**A303 Sparkford to Ilchester Dualling
PINS Reference: TR010036**

Comments of the draft Development Consent Order 2019

**Submitted by South Somerset District Council
on 8th February 2018**

A303 SPARKFORD TO ILCHESTER DUALLING
WORKS PLANS REGULATION 5(2)(J)
SHEET 1 OF 4

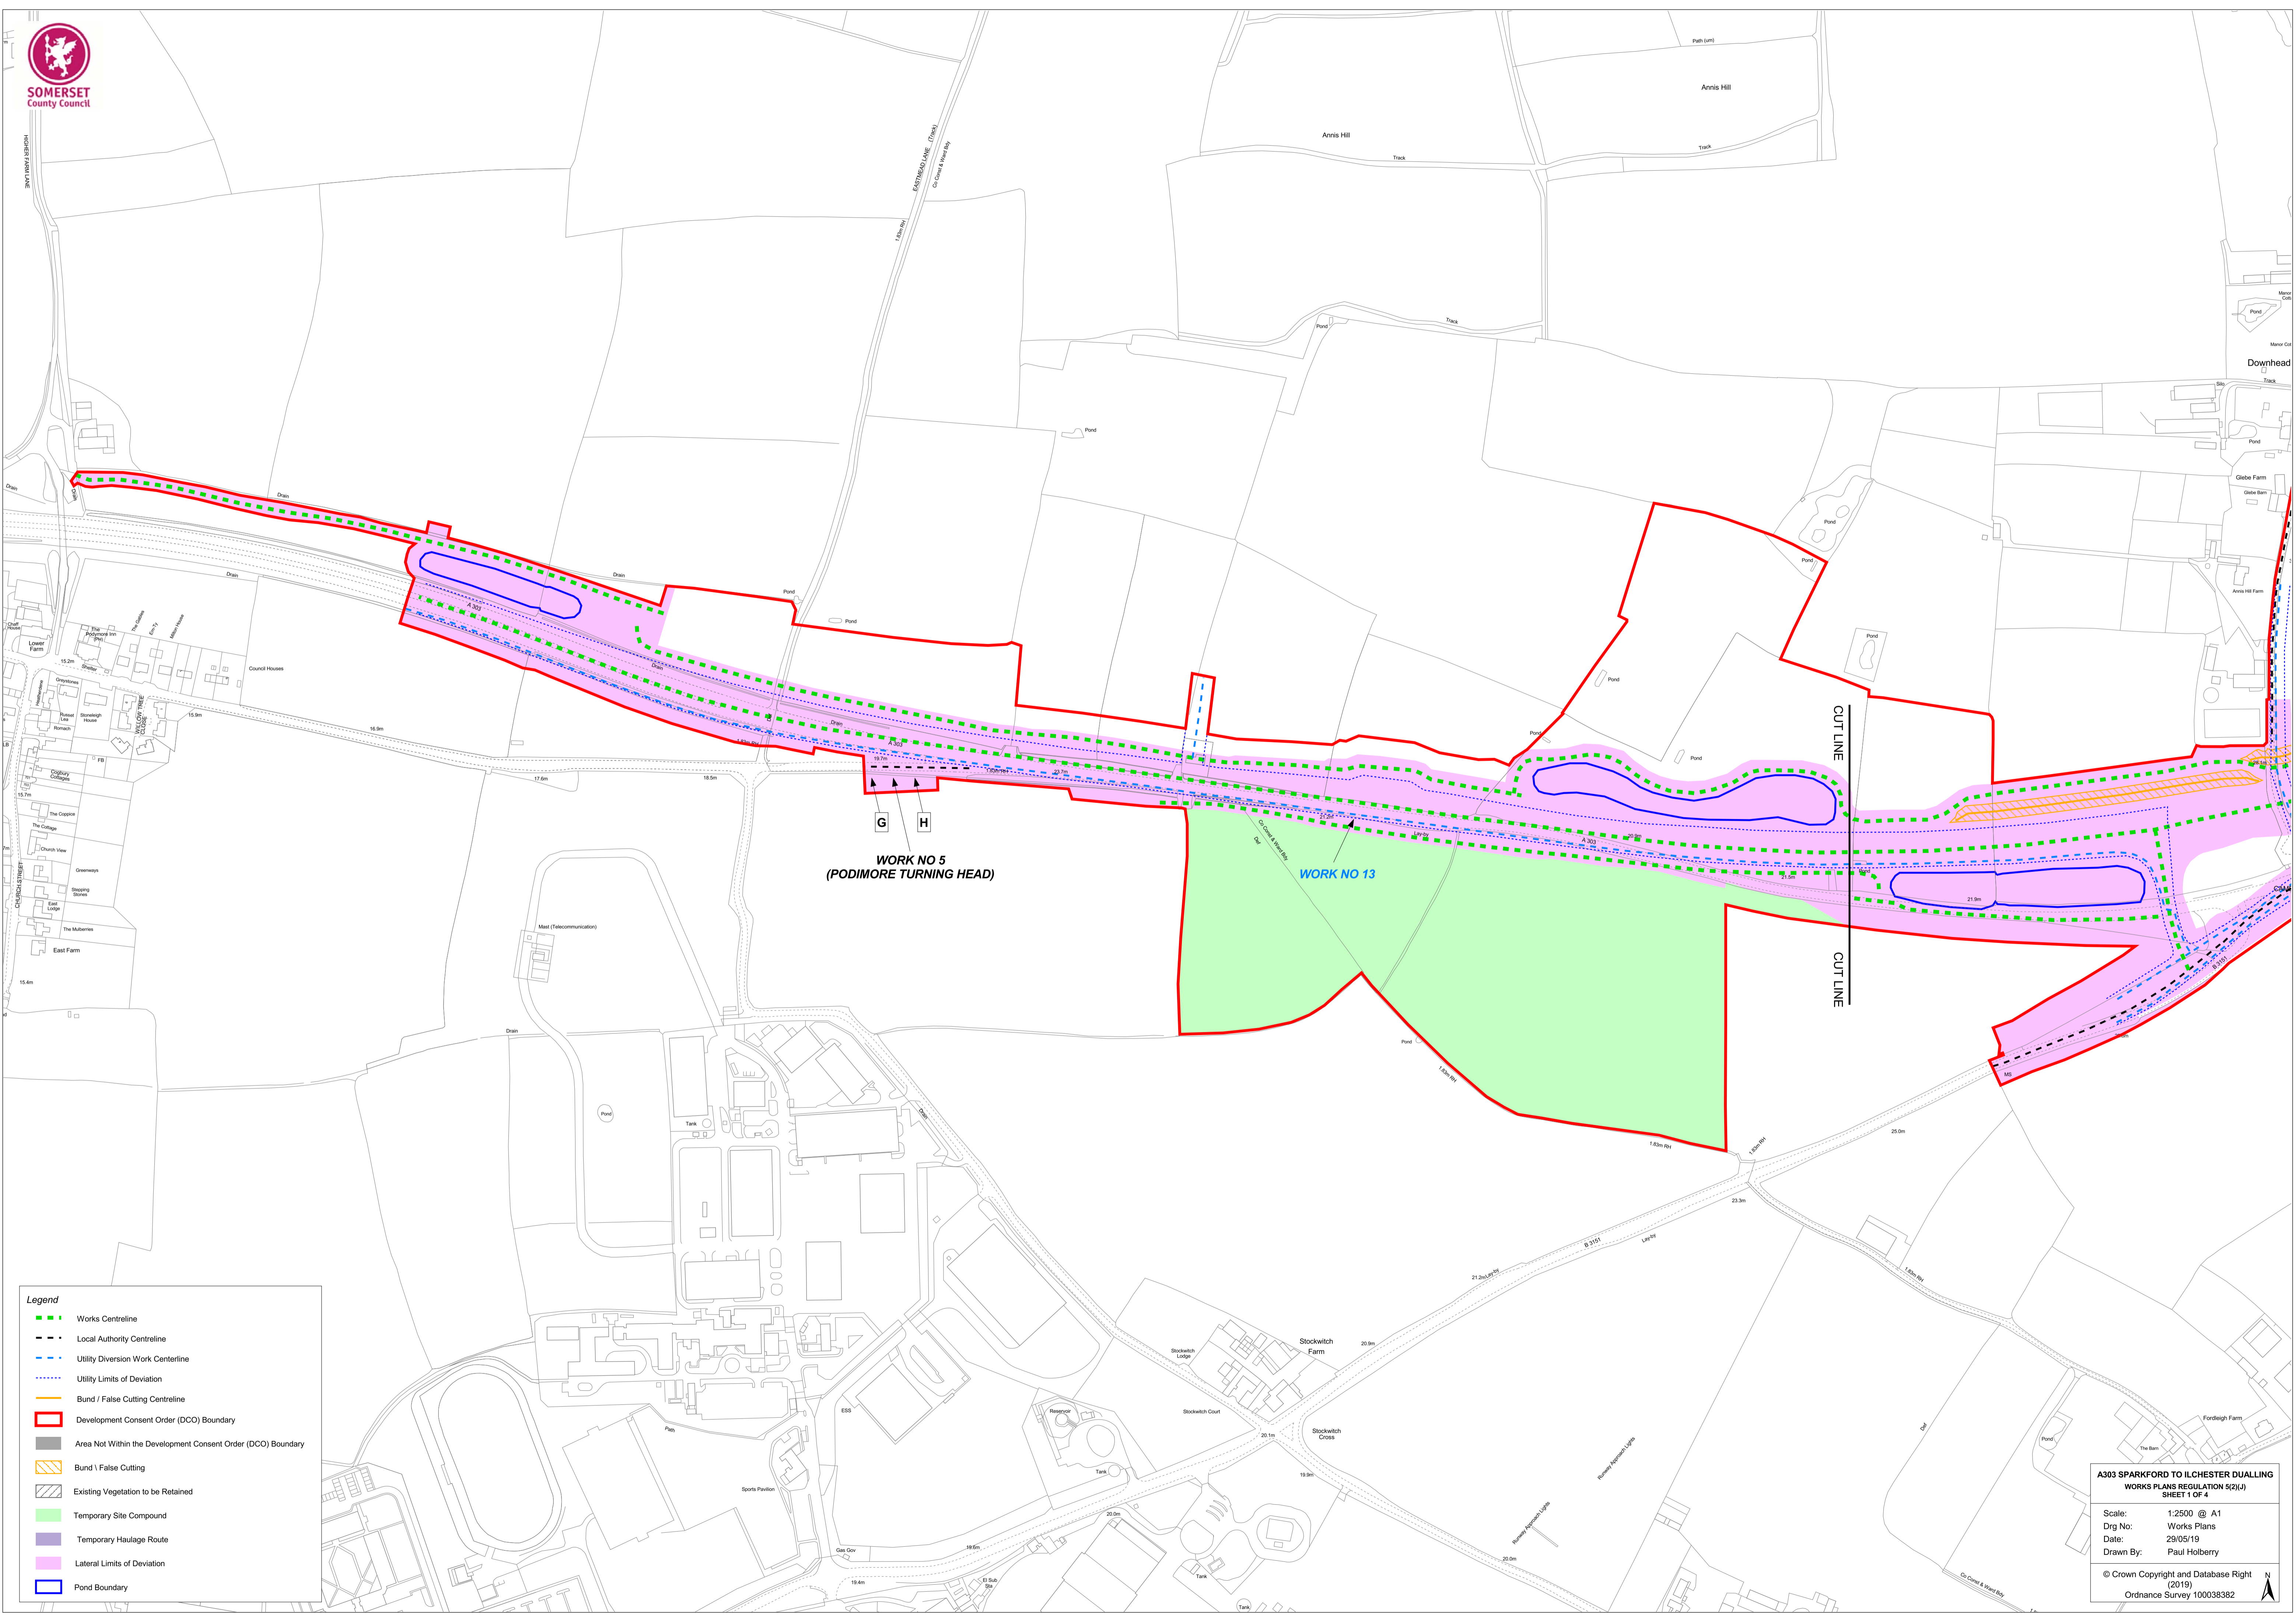
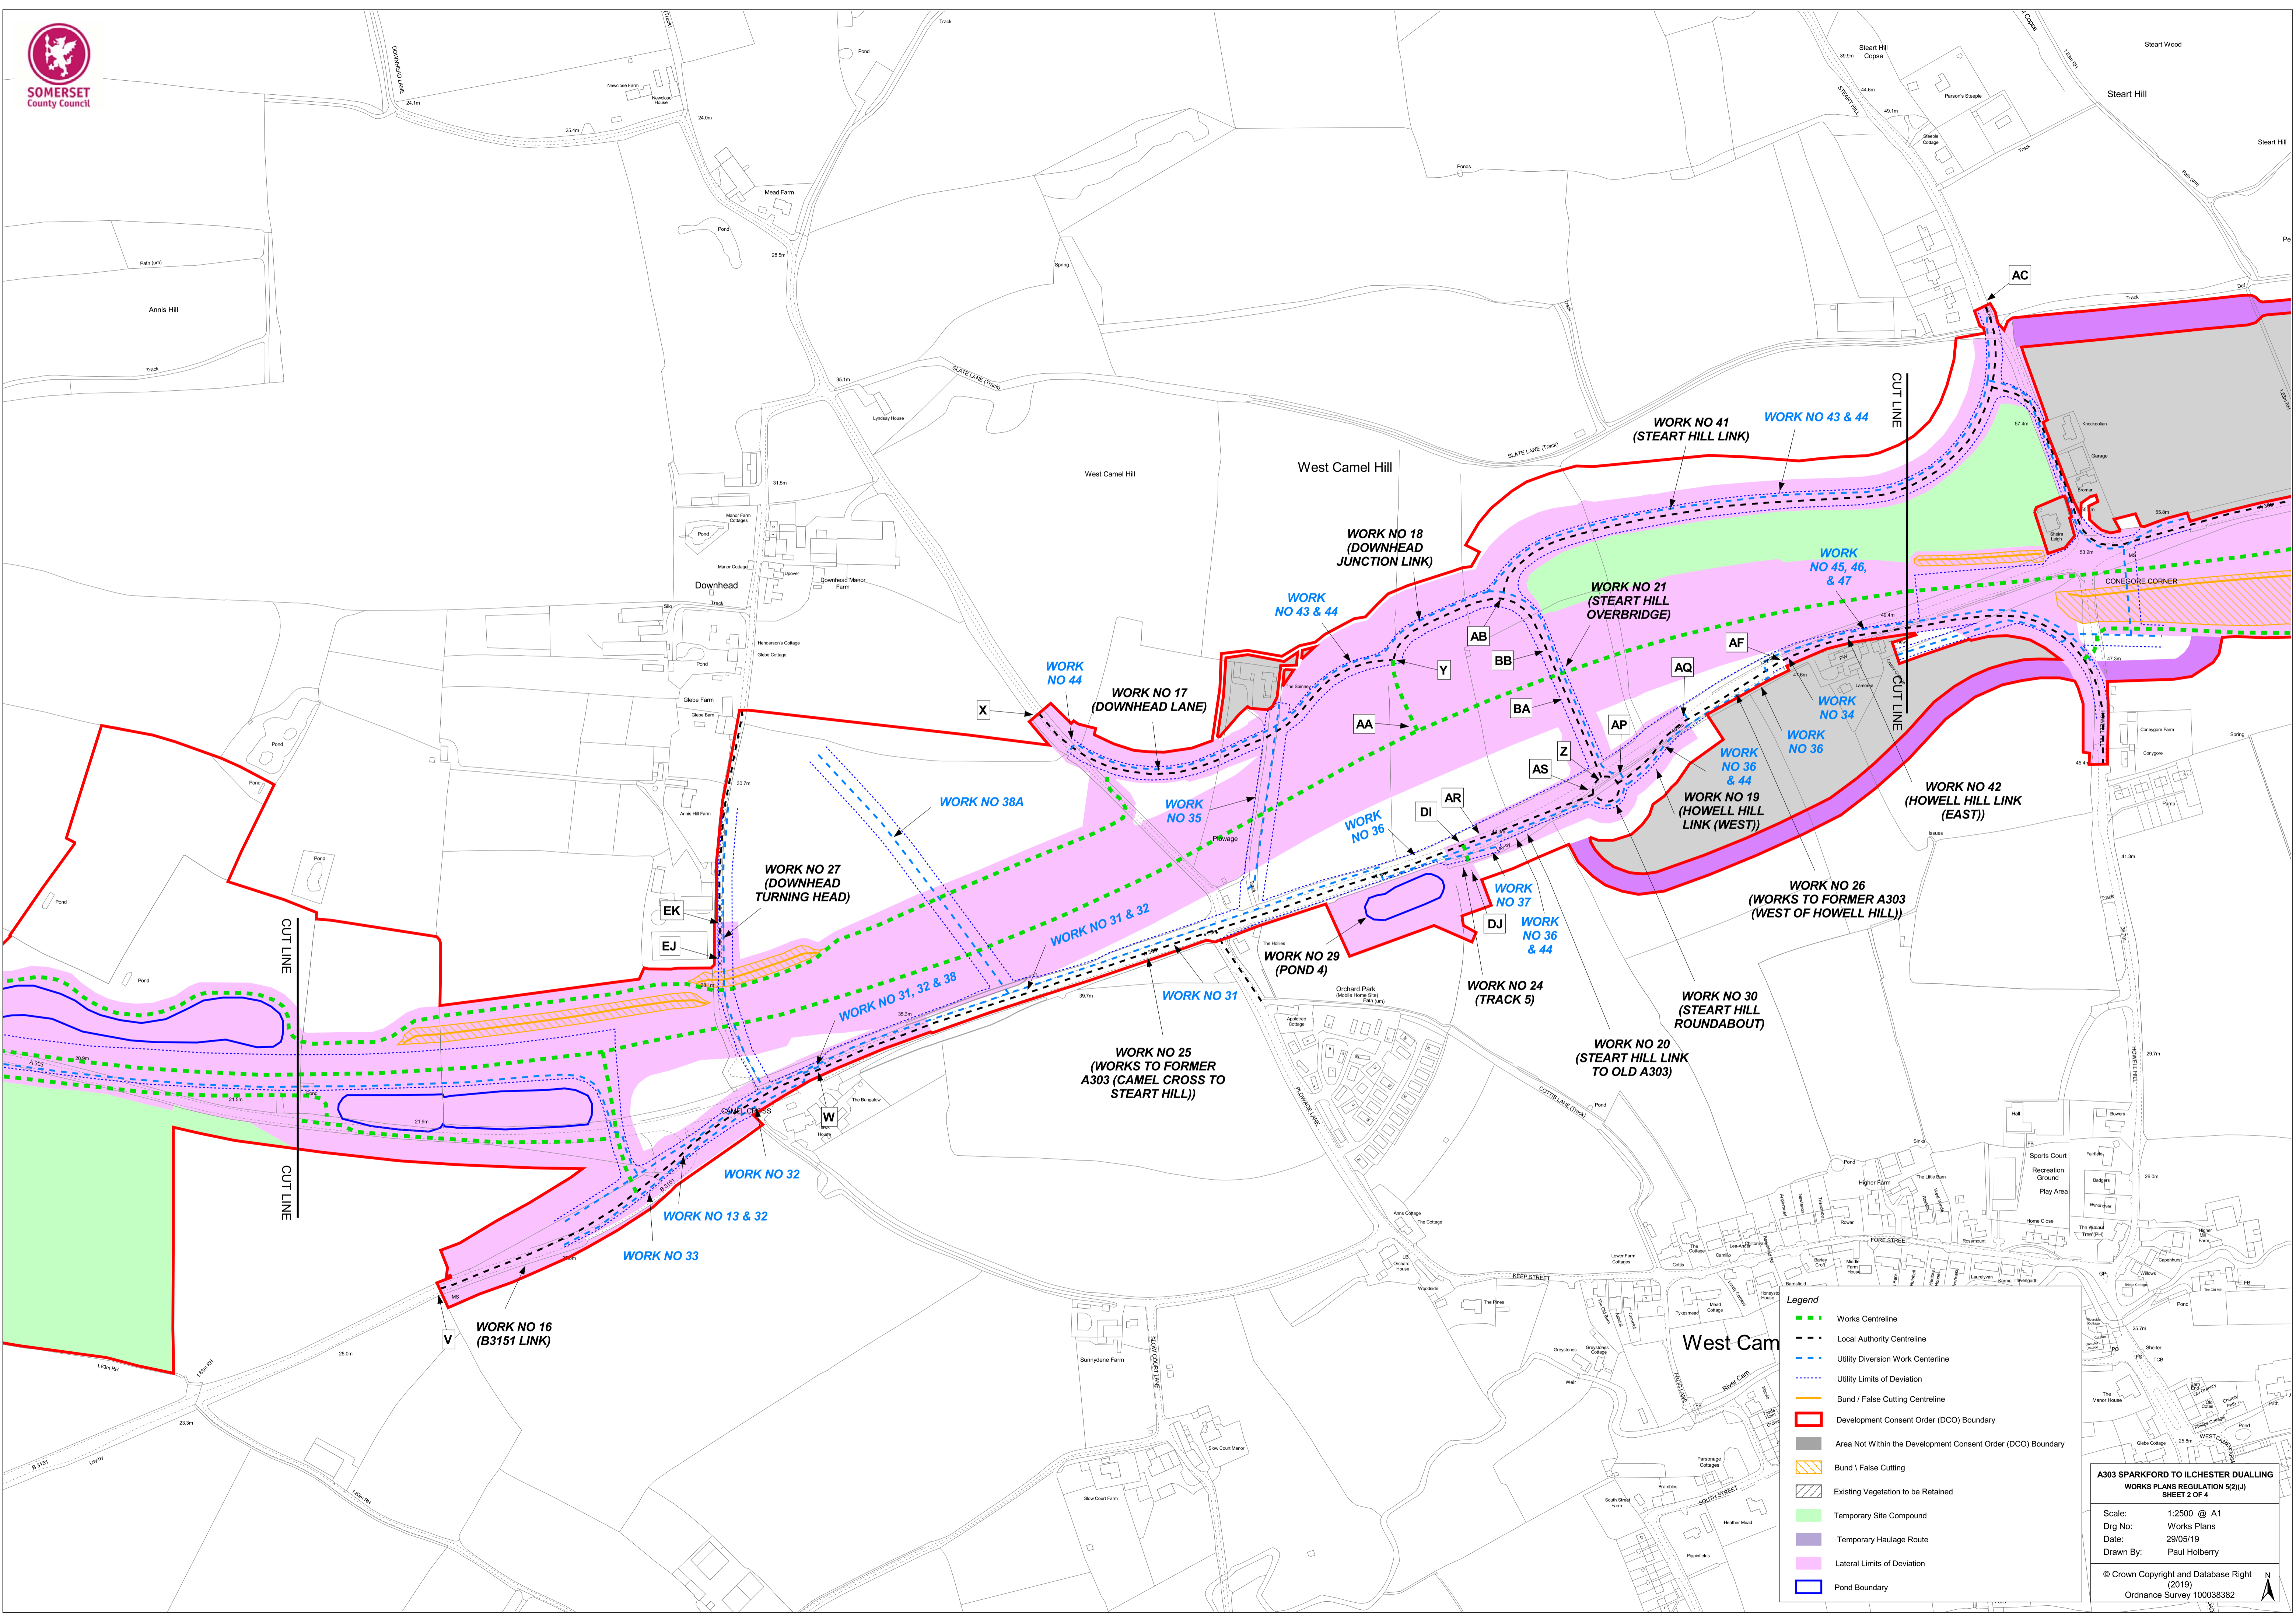
17.	Schedule 1 – Authorised Development	The District Council is seeking modification of some of the Works, i.e. relocation of Work No. 9, Pond 5.	The amendment will depend on discussions that are currently on-going
